From: [REDACTED]
Sent: 17 February 2014 17:06
To: Janice Chapman
Subject: RE: Felpham Sailing Club FP/232/12/

A couple of minor alterations are required to enhance the facilities. These alterations are all to the rear of the existing building with the introduction of two high level obscure glazed windows to the North elevations, a door to replace a window in the East elevation and the need to replace none-compliant water tanks with new on the flat roof.

PROPOSED NORTH ELEVATION 1:100

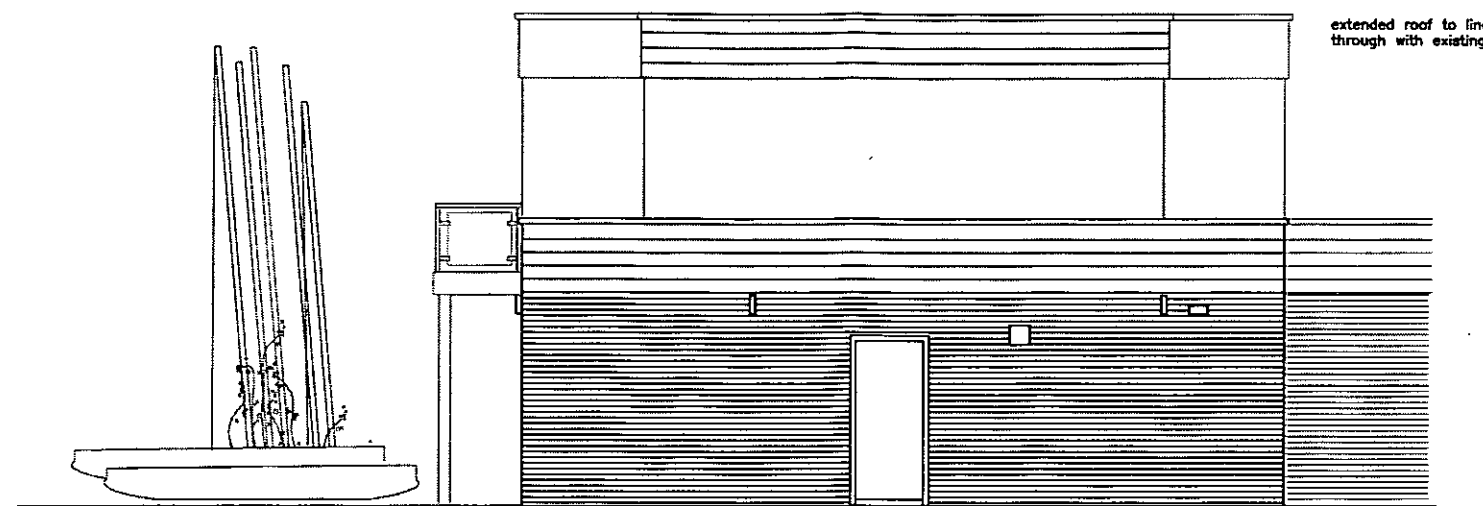
The alterations to the rear regarding the high level windows and a door in lieu of window on the east side can be accepted as a non-material amendment. Is there only one water tank, when scaled from the submitted plan this appears to be under 1m in height. Can you confirm this.

PROPOSED ~~WEST~~ ELEVATION 1:100
EAST.

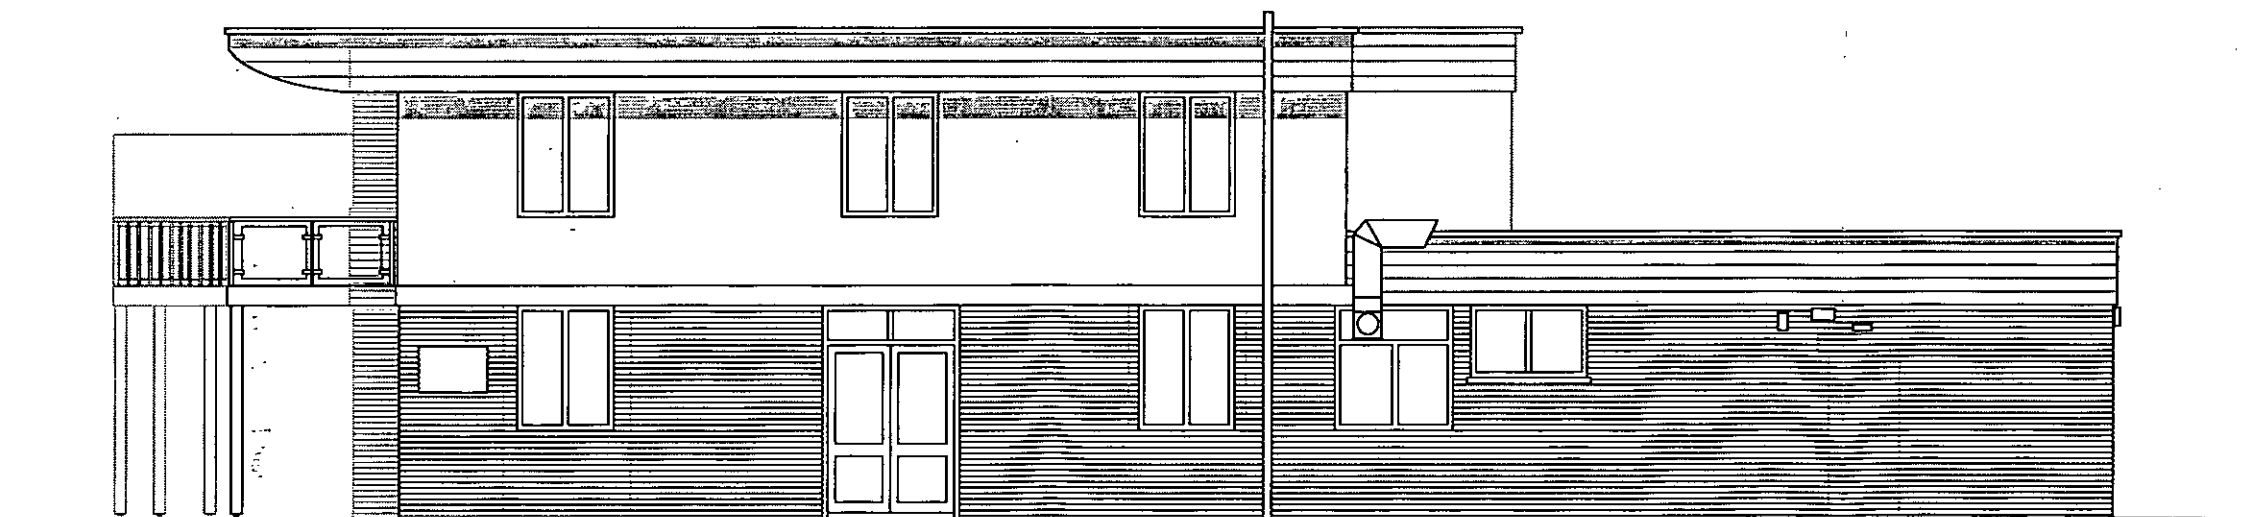
I note that the plan showing west elevation should read east elevation.

Thank you so much for your reply.
There is only one water tank proposed and it should be between 1-1.2m in height.
Drawing error noted and will be amended.
